**M25 Junction 10/A3 Wisley Interchange Improvement Plan – Issue Specific Hearing 2 and comments on WRs.**

Further to previous correspondence, I write to provide the Guide Association Trust Corporation and Girlguiding Greater London West (“GGLW”) written submission of oral case at Issue Specific Hearing 2 and some additional comments on the Written Representations of other parties.

Alternative Access – Option A (Traffic Signals)

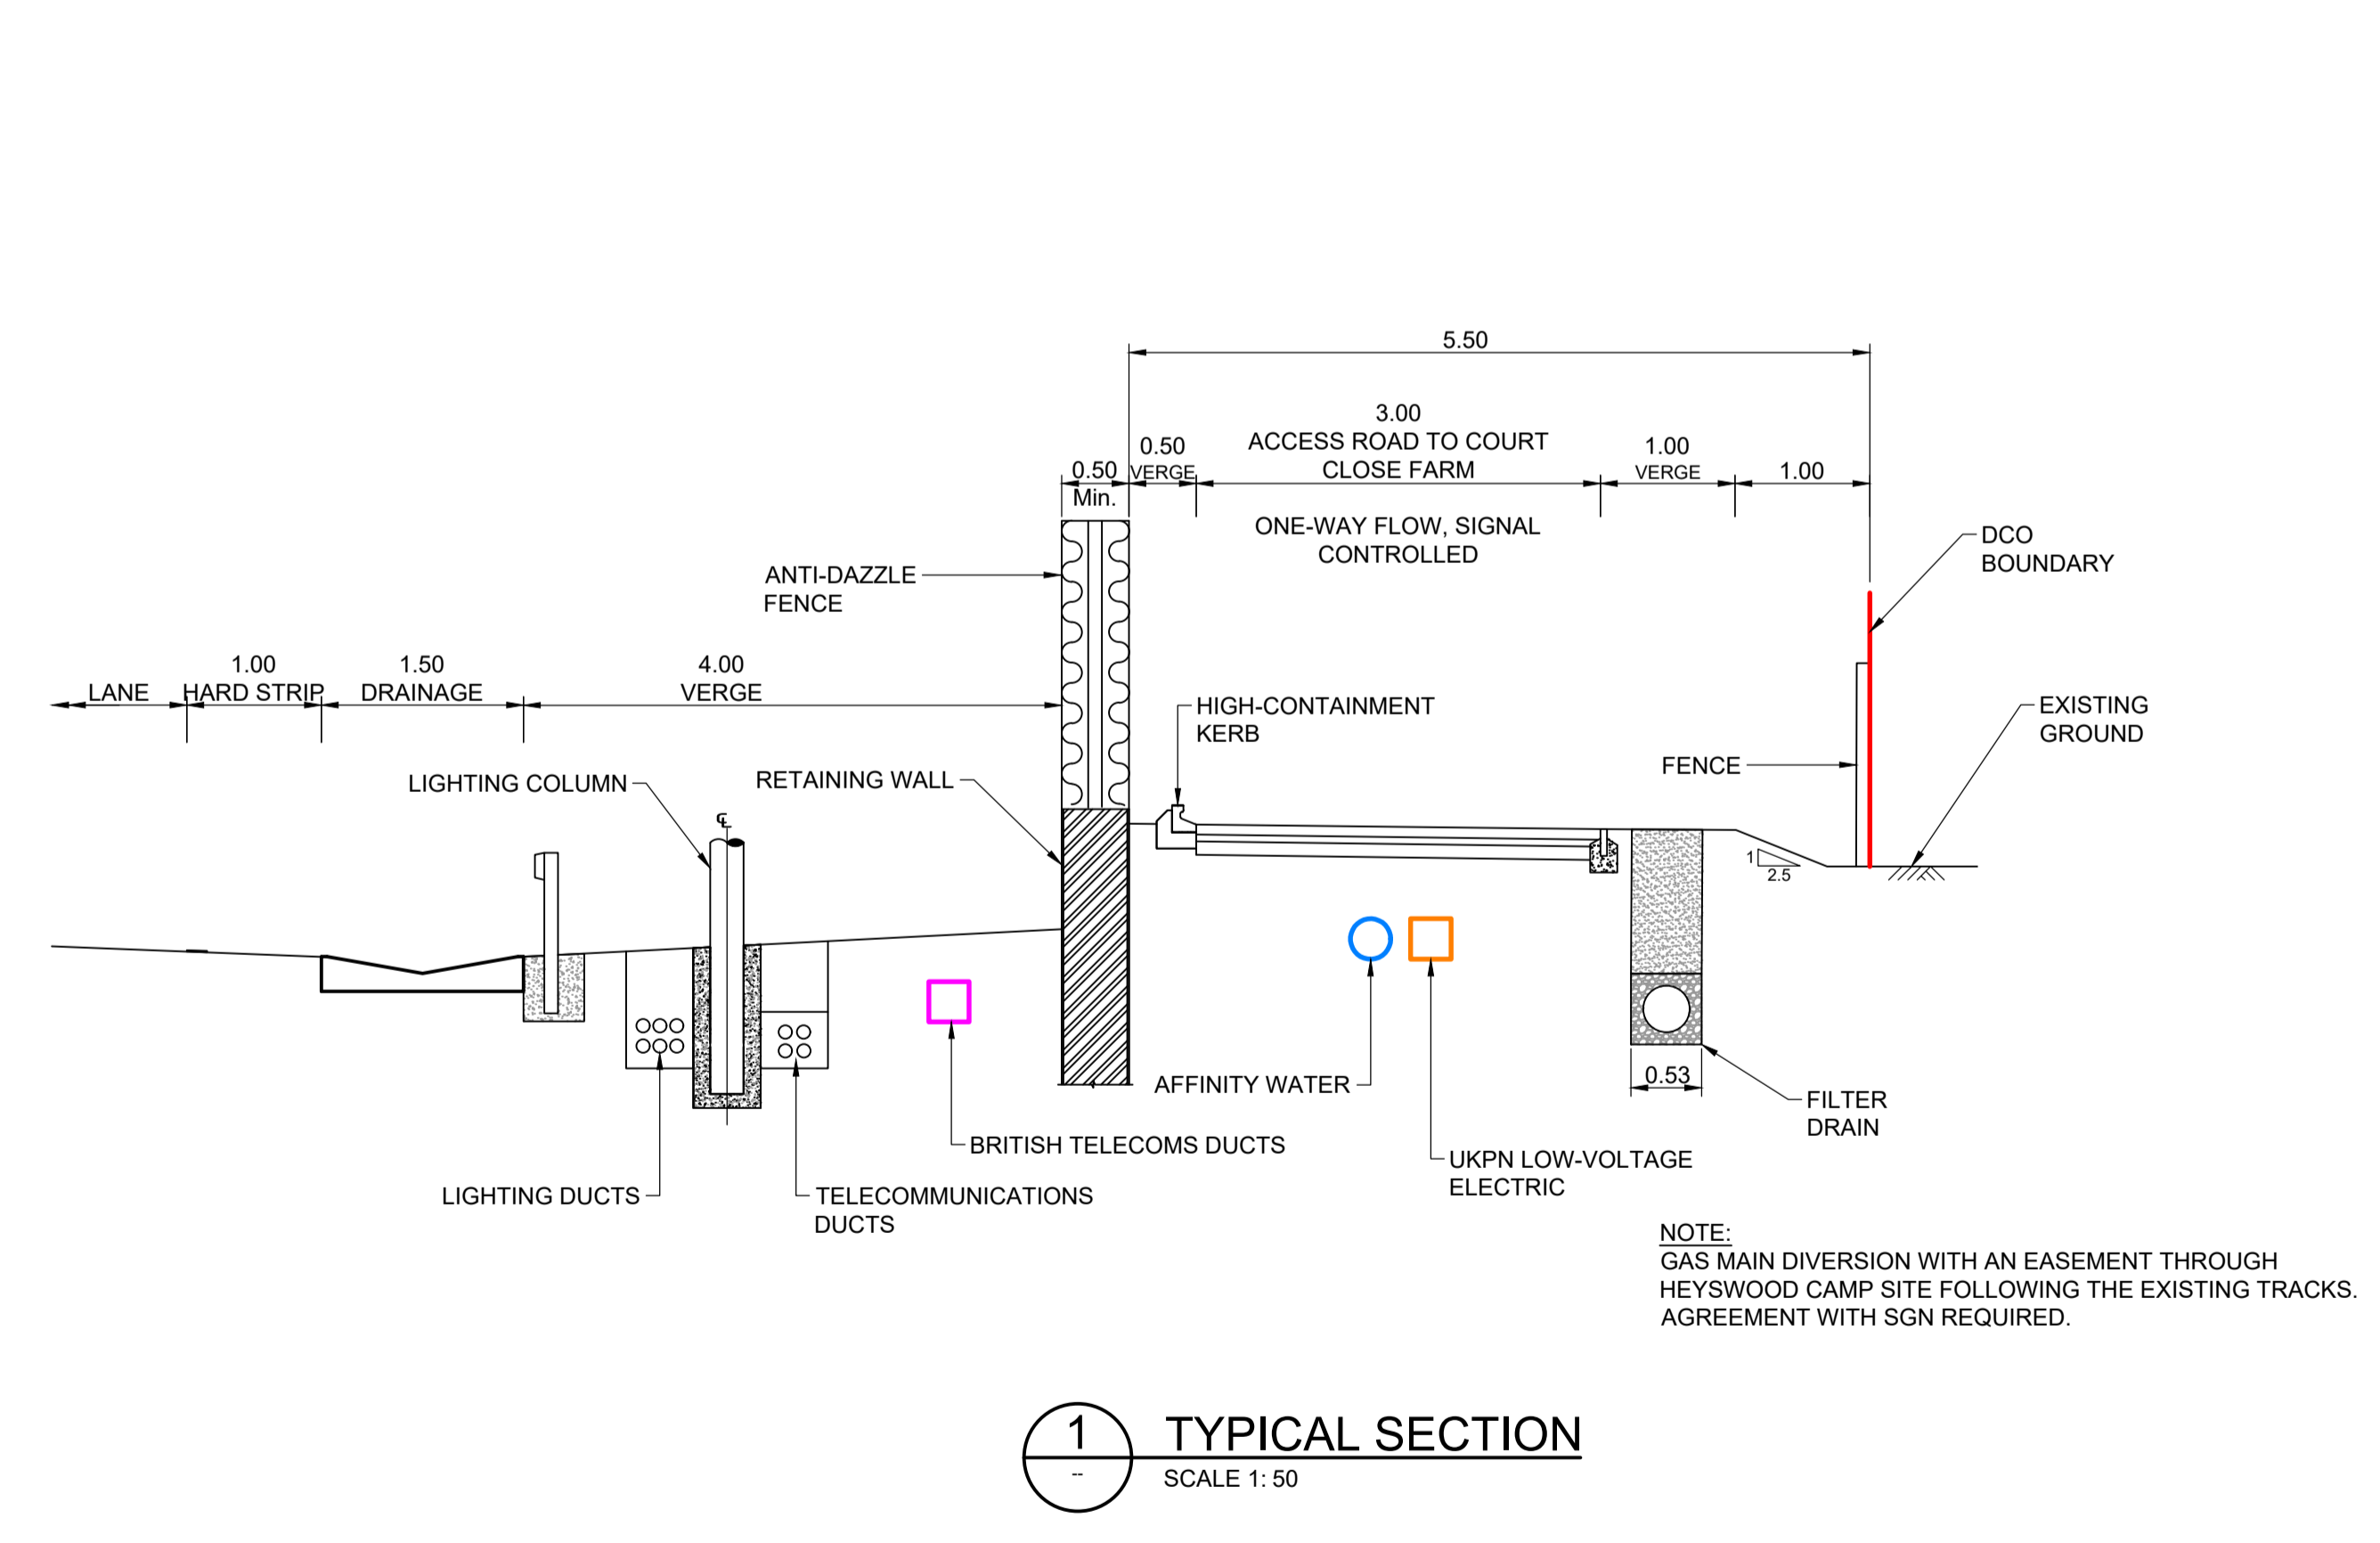
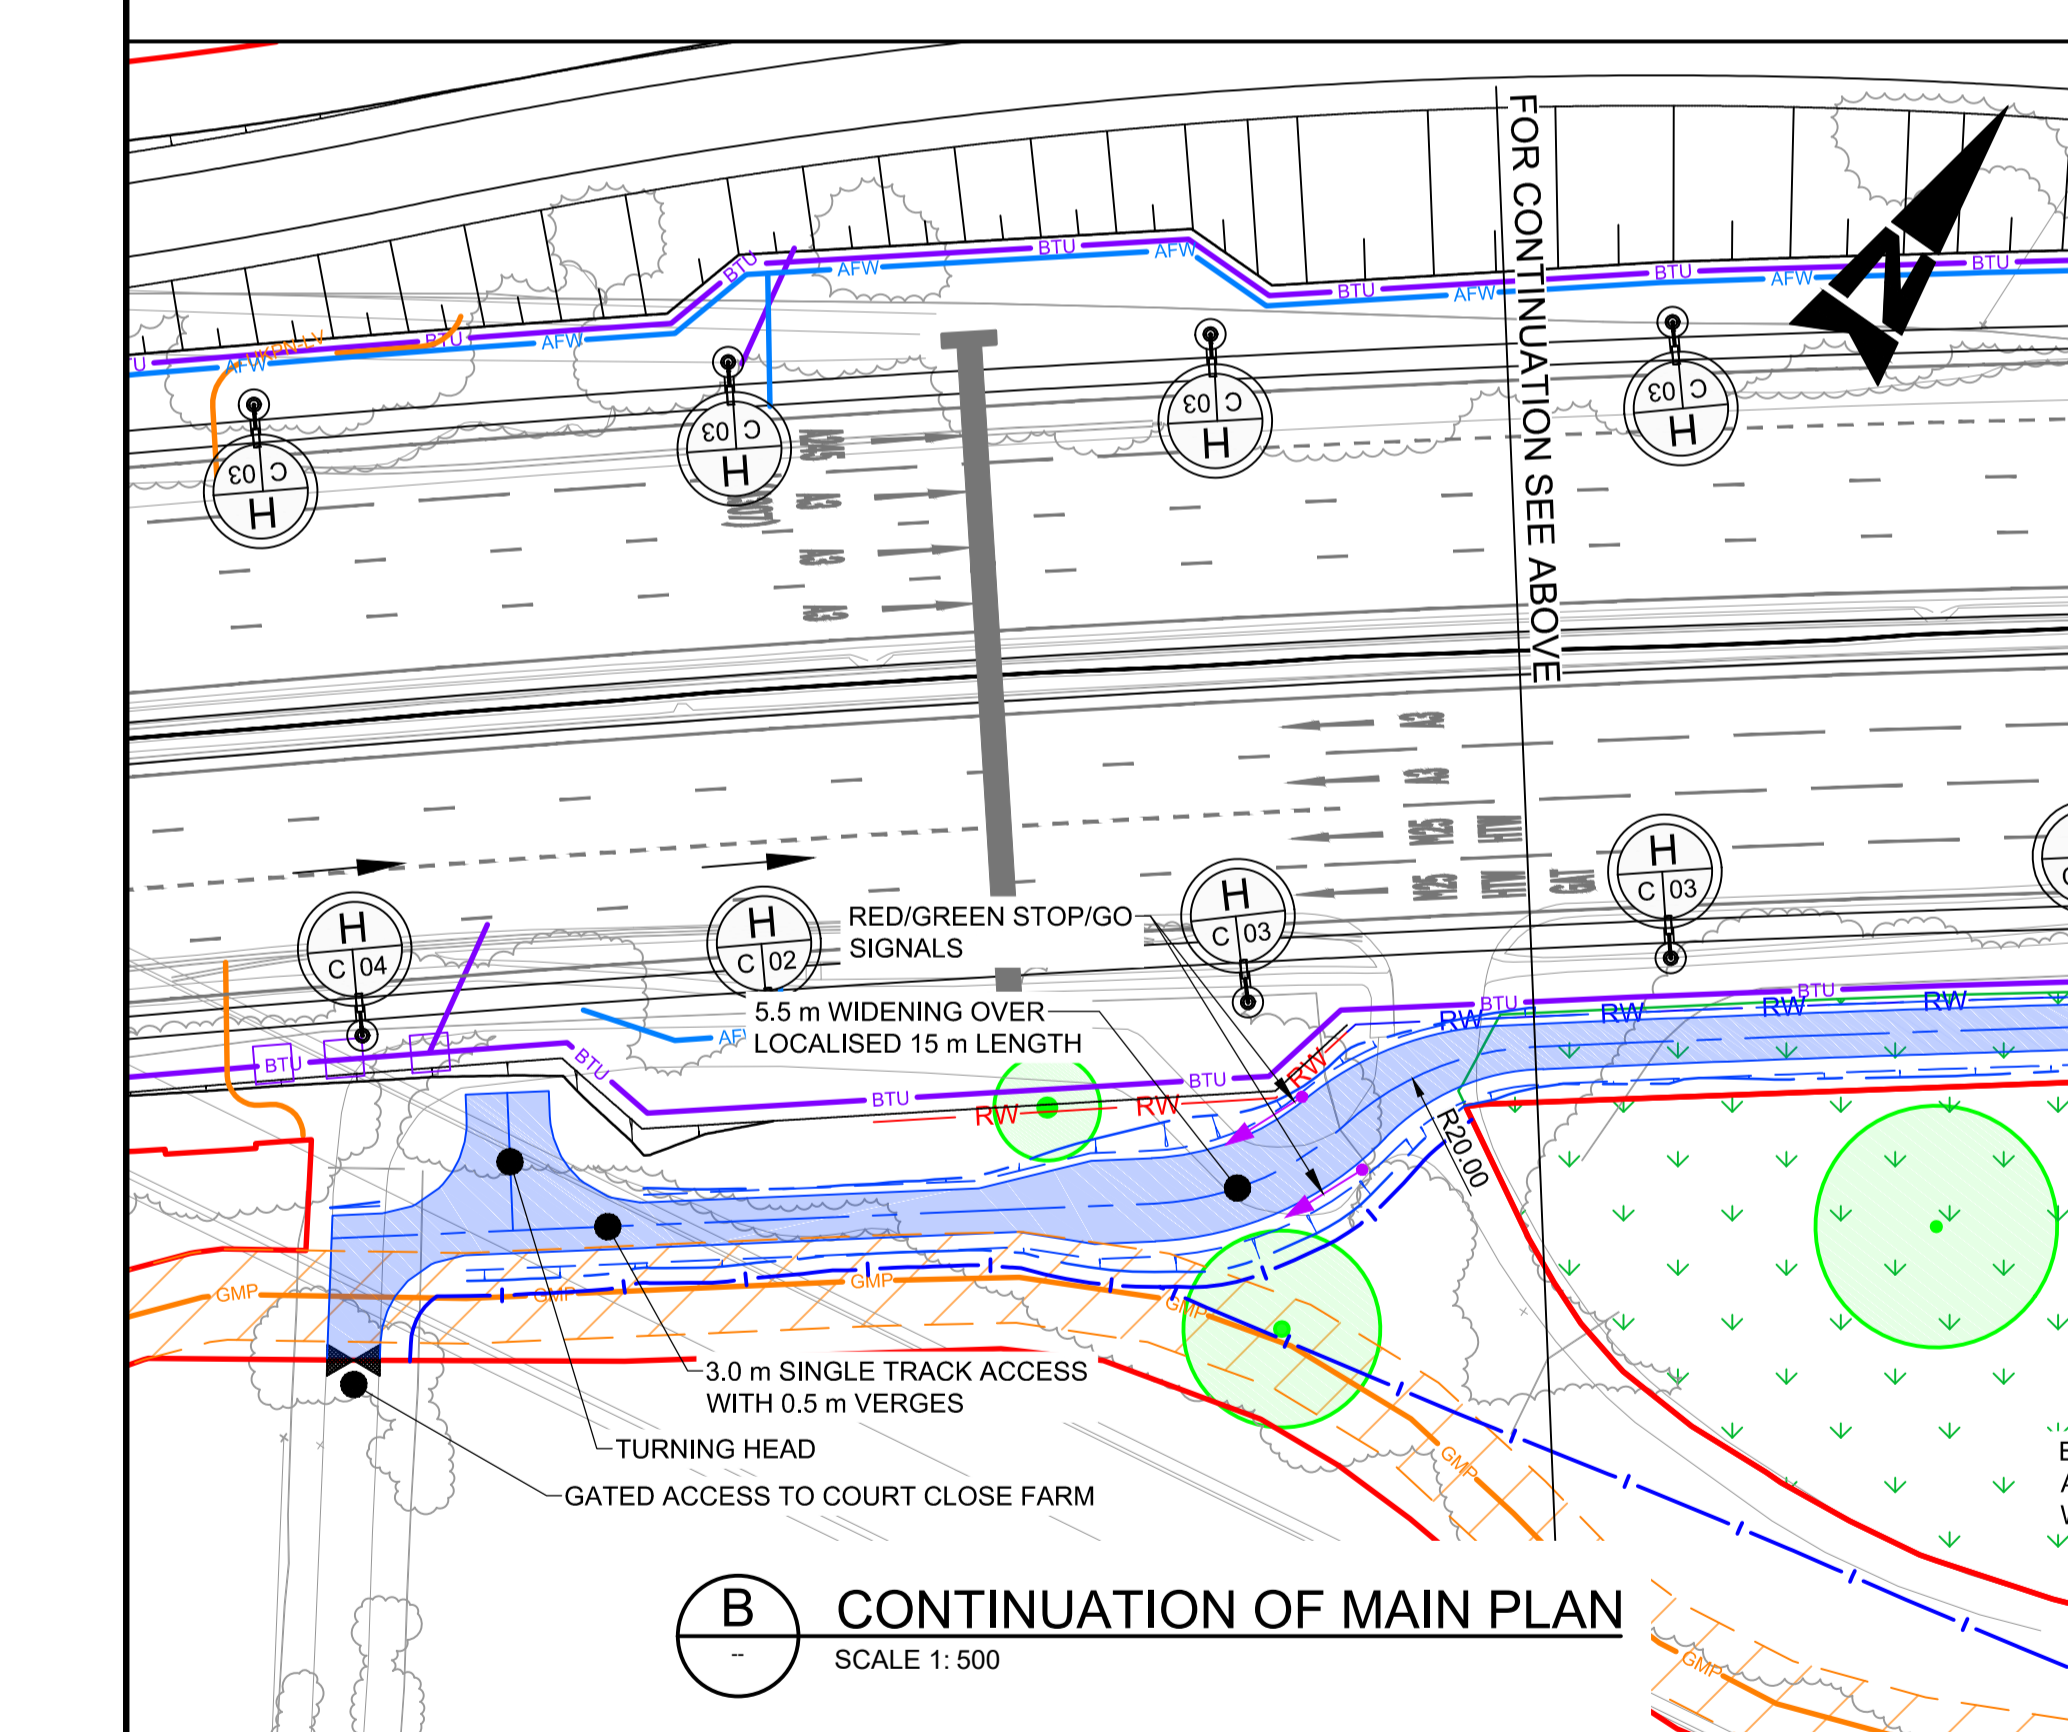
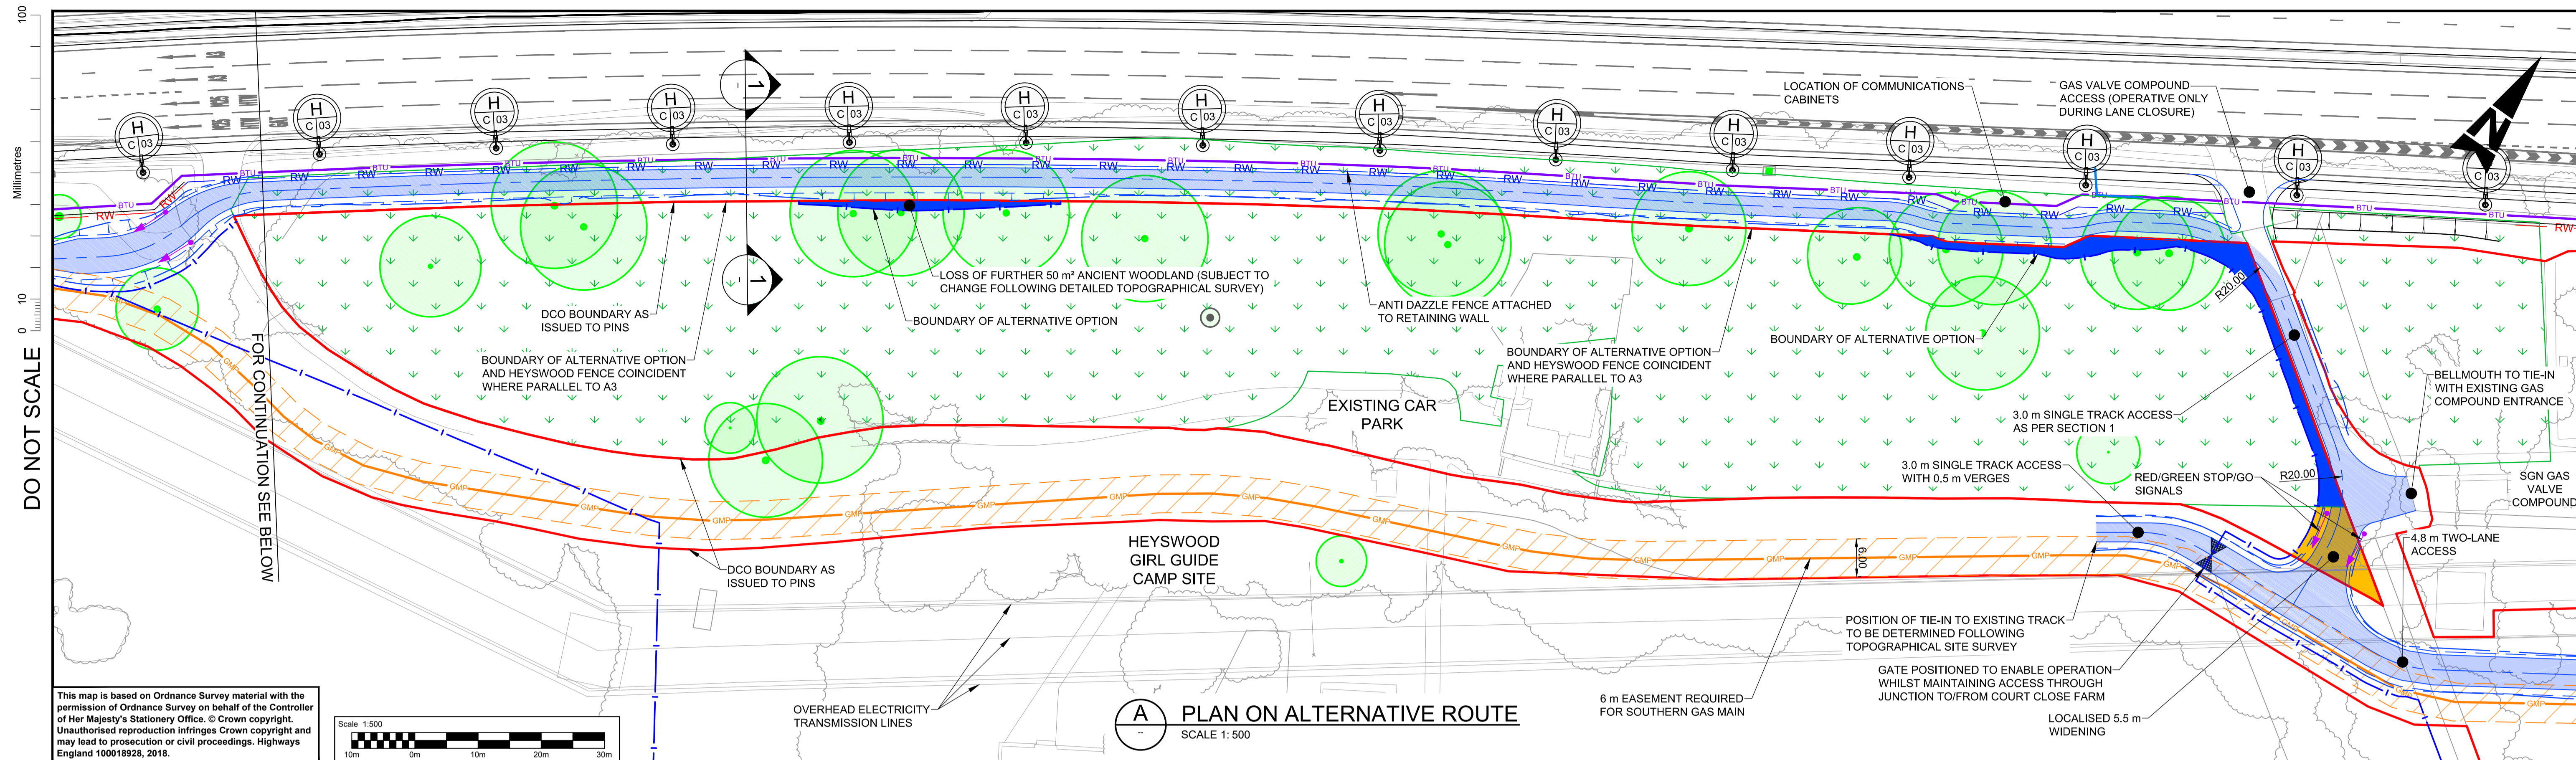
1. The alternative route we propose changes after the gas station and pylon at the north-east end of the site. At this point instead of entering our land, the Private Means Access to our neighbours would turn right down the current access track for the gas station and Park Farm to the A3. It will then need to curve left alongside the widened A3. This will then be a straight access road, parallel to the A3, down to the current entrance for Court Close Farm. (see appendix 1 adapted Access map)

2. Our alternative route keeps our camp site whole rather than severing approx. 20% which includes our warden’s bungalow, garage, tool shed and the ancient woodland area. (see appendix 2 labelled freeholder map).

5. The HE proposed route would result in the loss of our car parking area which would increase the risk to children and young people as they are dropped off and collected from the site.

9. We note that Surrey County Council advised at the hearing that a Private Means Access (PMA) needs to be only 3m rather than 4.8m wide. This means that the GLW alternative route would require less impact on the ancient woodland and less land take than previously calculated.
